London Luton Airport Expansion

Planning Inspectorate Scheme Ref: TR020001

**8.118 Applicant's Response to Issue Specific Hearing 4
Action 7 - Update on Road Safety Audits**

Report title:	Stage 1 Road Safety Audit Designer's Response- M1 Junction 10
Date:	November 2023
Document Reference and Revision:	TR020001/APP/8.118
Prepared by:	Neil Scott
On behalf of:	Luton Rising

Figure 4 - An extract from the interventions's drawing M1J10-NB-A-01

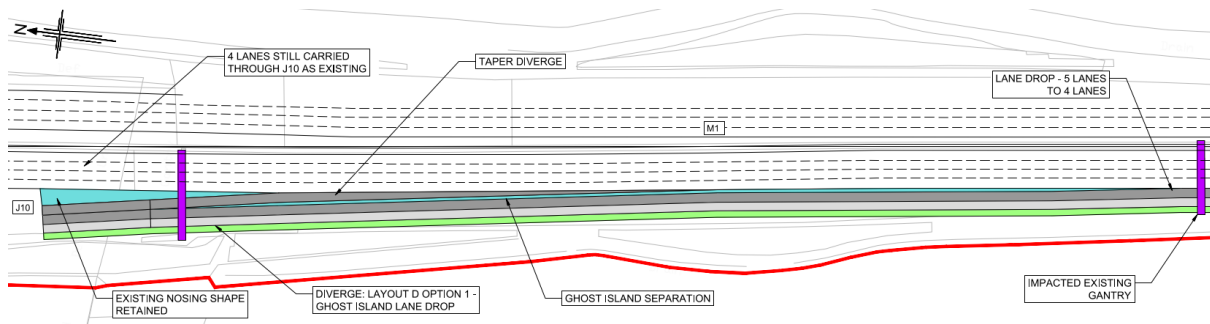
Ref.	RSA Problem	RSA Recommendation	Design Organisation Response	Overseeing Organisation Response	Agreed RSA Action
3.1	Drawing LLADCO-3C-ARP-SFA-HWM-DR-CE-0009 indicates that the length of the two-lane merge is to be extended by 150m. This may result in forward visibility of the merge point being compromised by an existing hidden dip in the northbound on-slip. This problem increases the risk of side swipe and loss of control type collisions.	Ensure that sufficient forward visibility of the merge is maintained.	Accepted. Forward visibility would be checked at the detailed design stage to ensure that appropriate visibility of the merge is maintained.	National Highways agree with the RSA. Traffic on the slip will be visible but the designer has agreed to checks.	Forward visibility would be checked at the detailed design stage to ensure that appropriate visibility of the merge is maintained.

Figure 8 - An extract from the intervention's drawing M1_J10_SB_Mer_Op2

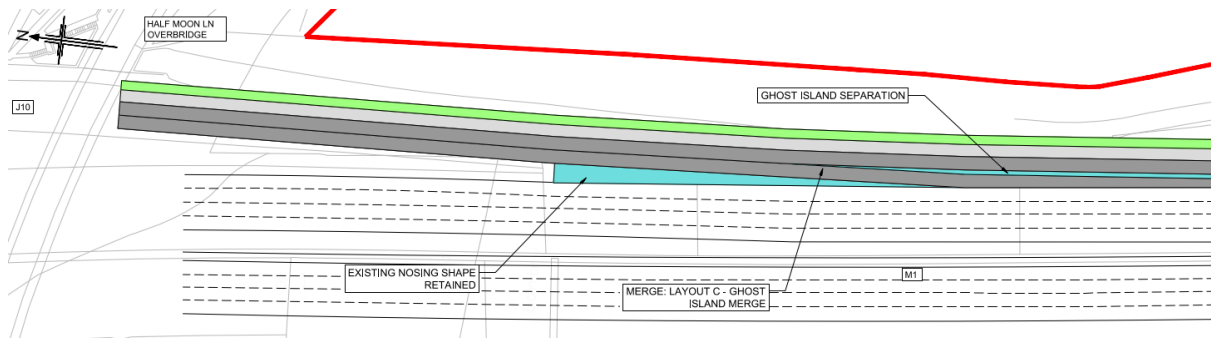
3.2	The brief provided for Road Safety Audit did not identify any departures from standard, however an offside merge has been proposed on the southbound on-slip in both phases 2a and 2b. This arrangement may increase the risk of road user confusion and it may be difficult for road users to merge into the segregated left turn lanes coming from the A1081. Road users may slow or stop when trying to merge increasing the risk of shunt type collisions with other road users heading southbound from the roundabout or shunt, sideswipe and loss of control type collisions with road users in the segregated left turn lanes.	Rearrange the proposed junction arrangement to eliminate the off-side merge.	Accepted. The proposed design of the merge could be amended to be a nearside merge. Alternatively, the exit lane off the circulatory could be removed as this would only serve errant vehicle movements i.e. M1 'U' turners or southbound vehicles that exit at J10 and then rejoin the M1 southbound carriageway. Almost all the vehicles using the southbound on-slip would be from the A1081 and would use the	National Highways agree with the RSA. The alternative designers response could hinder low numbers of U-turners and lead to erratic / late braking manoeuvres so suitable signing would need to be provided to inform road users of the route required to re-join the M1. Merging into the offside can also result in slower moving traffic that would typically be in lane 1 (HGV) needed to merge into potentially faster moving traffic,	NH comments on the alternative noted and any amendment to the design would be supported by appropriate amendments to the signage. NH comments on merging noted however the arrangements proposed by the Auditor and accepted by the Design Organisation are in keeping with the existing arrangements at the junction.

3.3	<p>In Phase 2a and Phase 2b a two lane segregated left turn from the A1081 onto the M1 southbound slip road has been proposed. The existing southbound lane from the M1 J10 roundabout is proposed to join the segregated lanes with a short length of off-side merge. No details regarding infrastructure or stopping sight distances have been provided. Items such as VRS and signs between the segregated left turn lanes and off-side merge may obscure visibility for road users. This issue may increase the risk of side swipe, shunt, and loss of control type collisions. This</p>	<p>Provide sufficient intervisibility between the merge and segregated left turn lanes.</p>	<p>Accepted. See above response to Item 3.2 regarding the design or removal of the merge. If the exit off the circulatory is retained, there is scope to amend the alignment of the segregated left turn and separating island in order to accommodate potential VRS, signage and visibility requirements. This would be addressed at the detailed design stage.</p>	<p>National Highways agree with the RSA.</p> <p>It would be interested to explore the potential for closing the eastern circulatory or S/B merge exit as mentioned. That could remove a couple of issues, but signing for route finding would be key.</p>	<p>Amend the alignment of the segregated left turn and separating island in order to accommodate potential VRS, signage and visibility requirements. This would be addressed at the detailed design stage.</p> <p>The opportunity to close the eastern circulatory or southbound merge will be considered at the detailed design stage.</p>

3.4	<p>In Phase 2a a two-lane segregated left turn from the A1081 onto the M1 southbound slip road has been proposed. The existing southbound lane from the M1 J10 roundabout is proposed to join the segregated lanes with a short length of off-side merge, this merge is followed immediately by a section of informal two-lane merge in advance of joining the main carriageway on the M1. Insufficient road space for the merges may increase the risk of side swipe and loss of control type collisions.</p>	<p>Ensure that sufficient road space is provided for road users to safely merge.</p>	<p>Accepted. See above response to Item 3.2 regarding the design or removal of the merge. It is noted that the proposed amendments to the white lining south of the offside merge increase the width of the on-slip as well as the overall merging length with the mainline by some 175m. The width of the slip is sufficient to extend the white lining to formalise the two lane section beyond that shown on the existing drawings and to extend the two lane section prior to the secondary merge. This can be addressed as part of the detailed design.</p>	<p>National Highways agree with the RSA.</p>	<p>As part of the detailed design amend white-lining to maximise the length of the two lane section.</p>
